Our Ref: BR/52/18/PL
Your Ref:

Town & Country Planning Act 1990 (as amended)
Town and Country Planning (Development Management Procedure) (England) Order 2015
Application for Planning Permission

Development Change of use from mixed use development consisting of Dental Surgery (D1 Non-Residential Institutions), night club (Sui Generis) & part residential (2 No. units existing) (C3 Dwellinghouse) to conversion to 8 No. flats with associated services (6 No. new units). This application may affect the setting of a listed building.

Location Bradlaw House 5 Sudley Road Bognor Regis

North-East Elevation 1:100

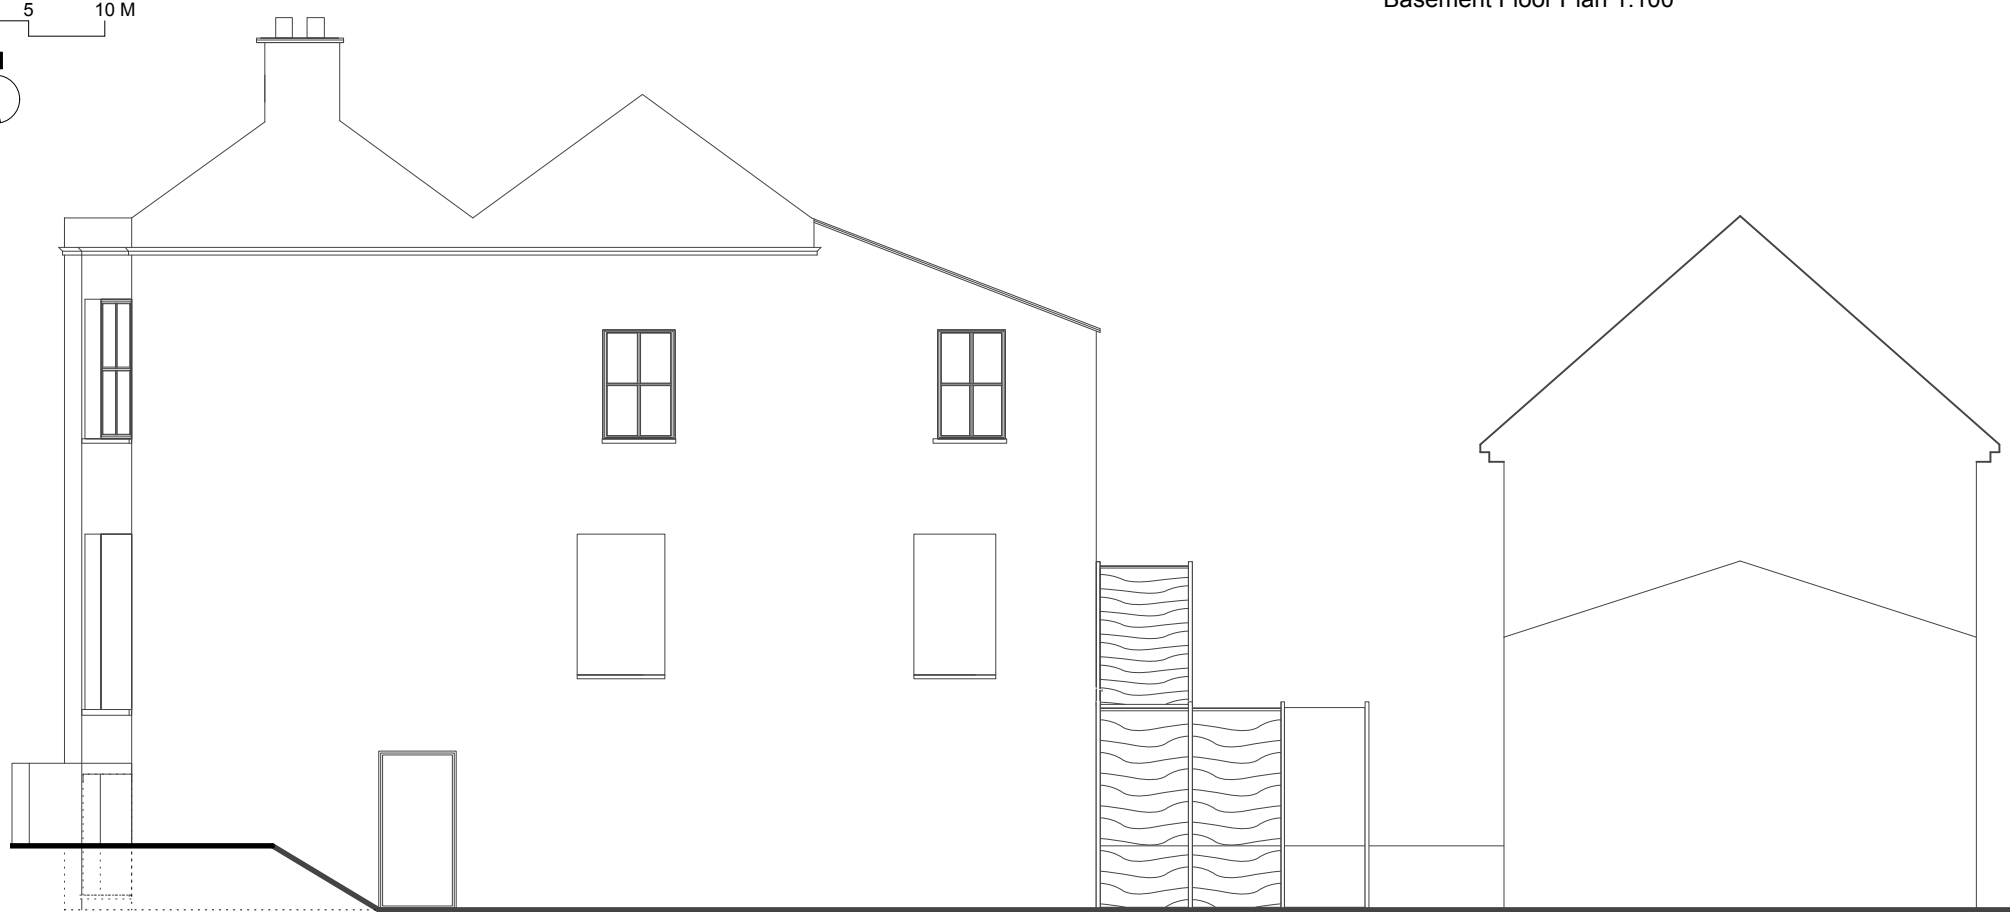
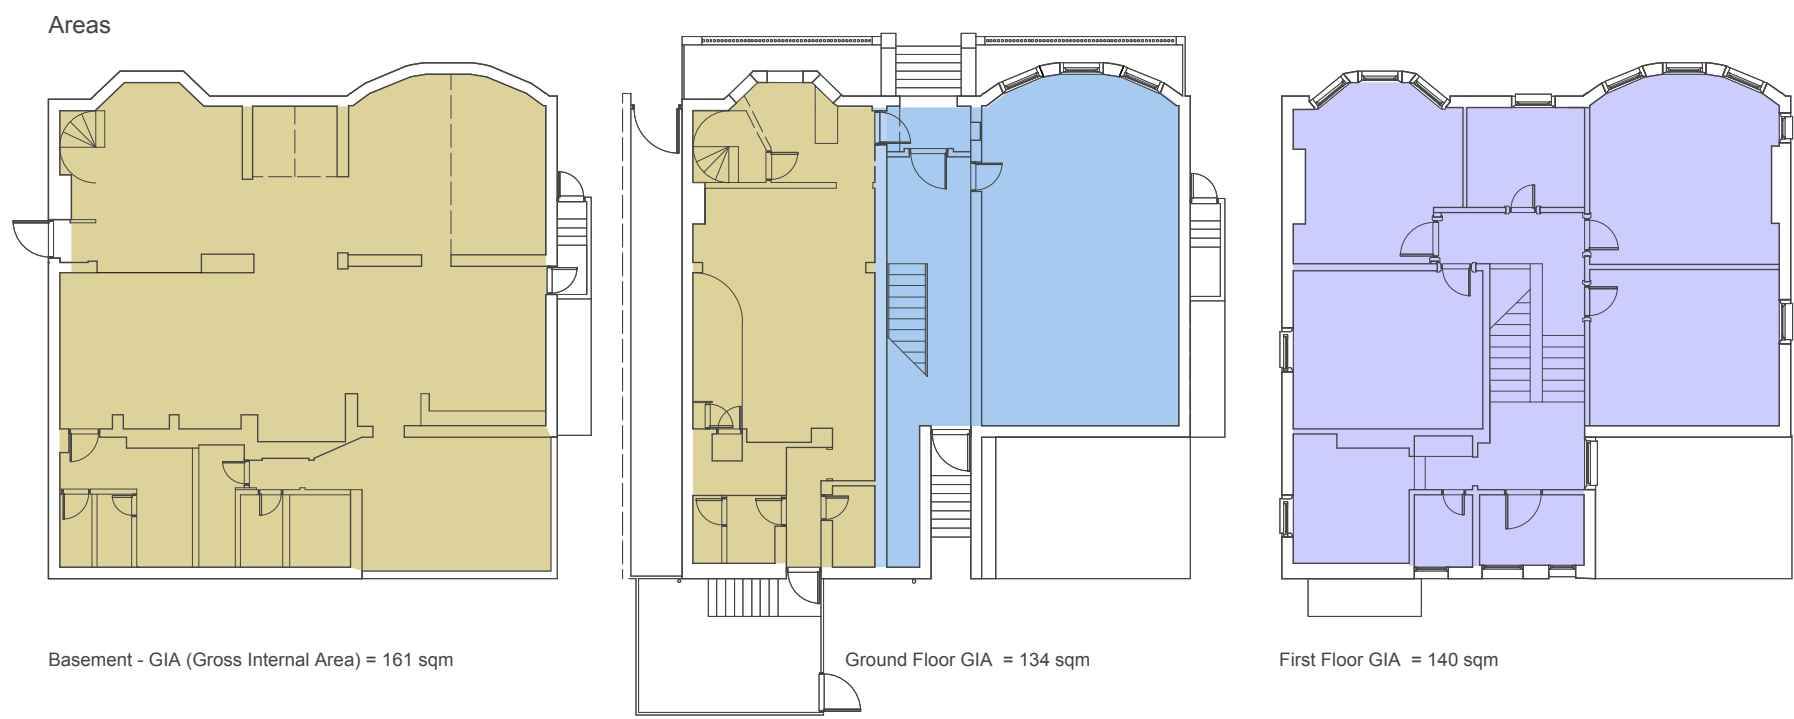
The existing NE elevation and basement plan do not accord. Please amend accordingly.

The existing NW elevation and ground floor plan do not accord. Please amend accordingly.

South-East Elevation (Proposed) 1:100

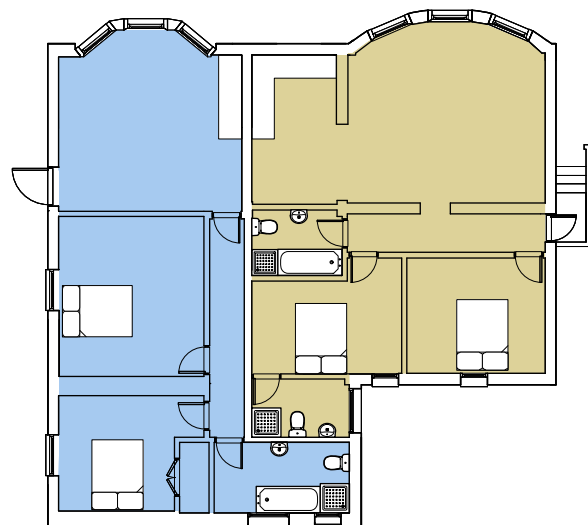
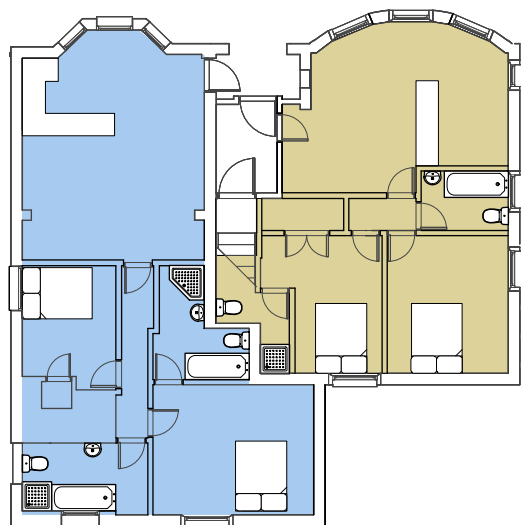
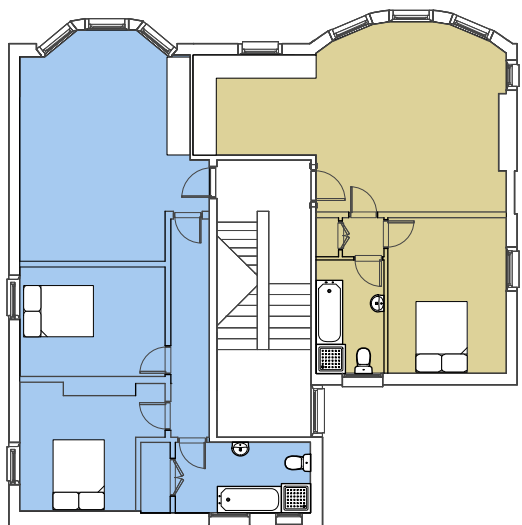
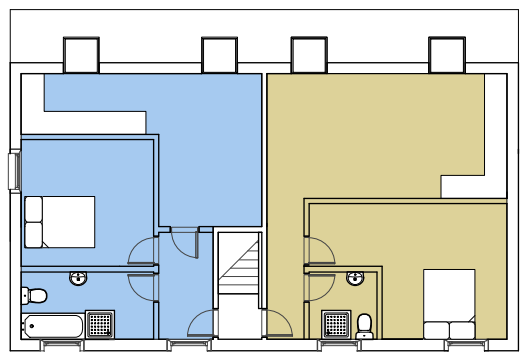
The proposed SE elevation and ground floor plan do not accord. Please amend accordingly.
